Our ref: St Anthony of Padua Catholic School Redevelopment-Mod-2 (SSD-8865-Mod-2)

28 October 2022

Subject: Request for Additional Information

L-MP10

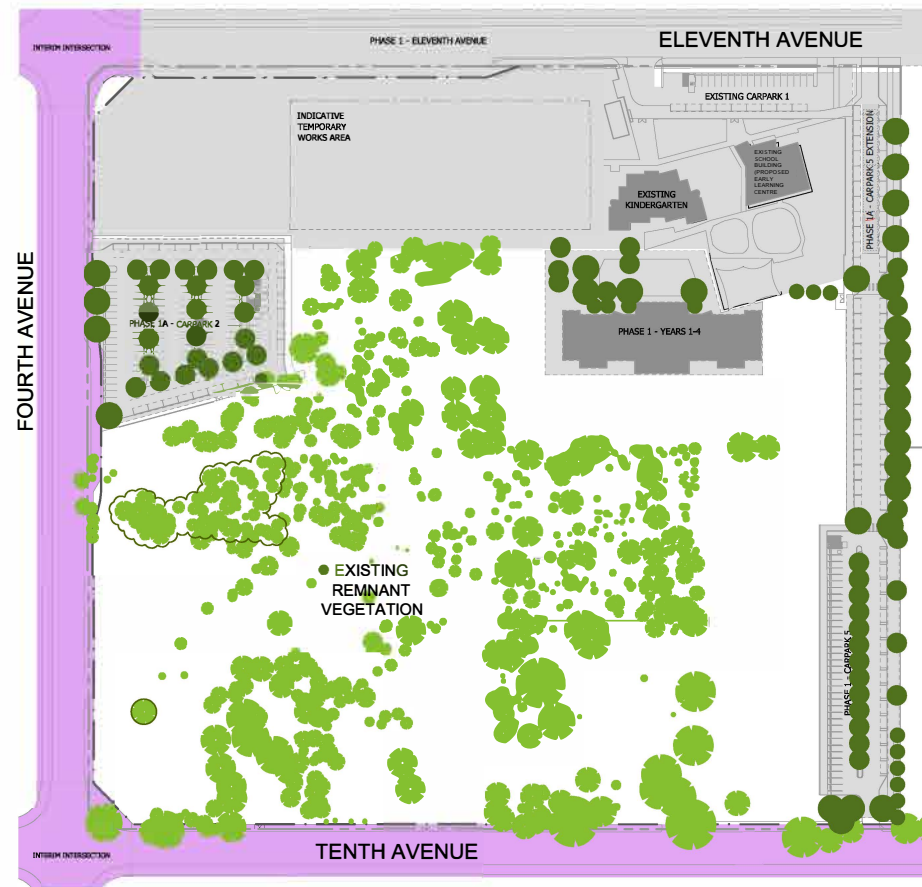
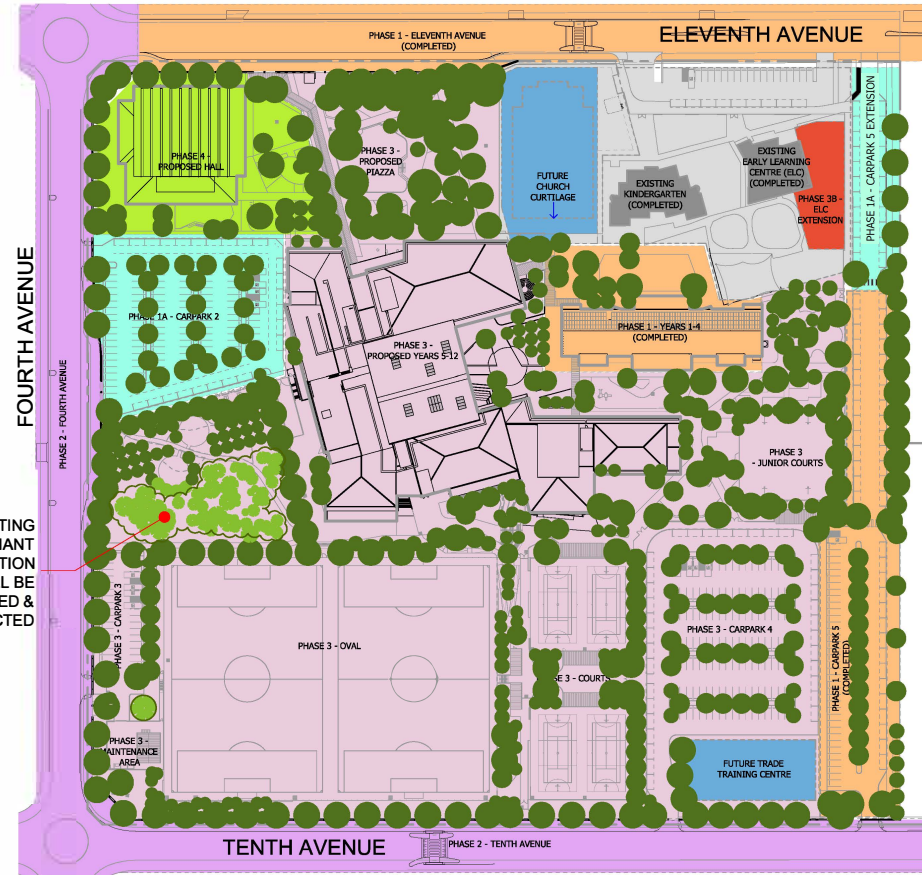
- The proposed amended condition no A2, table of the drawings does not include all updated drawings such L-MP10, Rev 7, AA0102, Rev D , AA2001, rev F, AA 6801, rev H, AA 2001, Rev G and list of all updated Landscape drawings.
- The proposed amended condition no A2, table of the drawings include the SK0018 Rev A drawing which has not been provided. Please address the above matters.
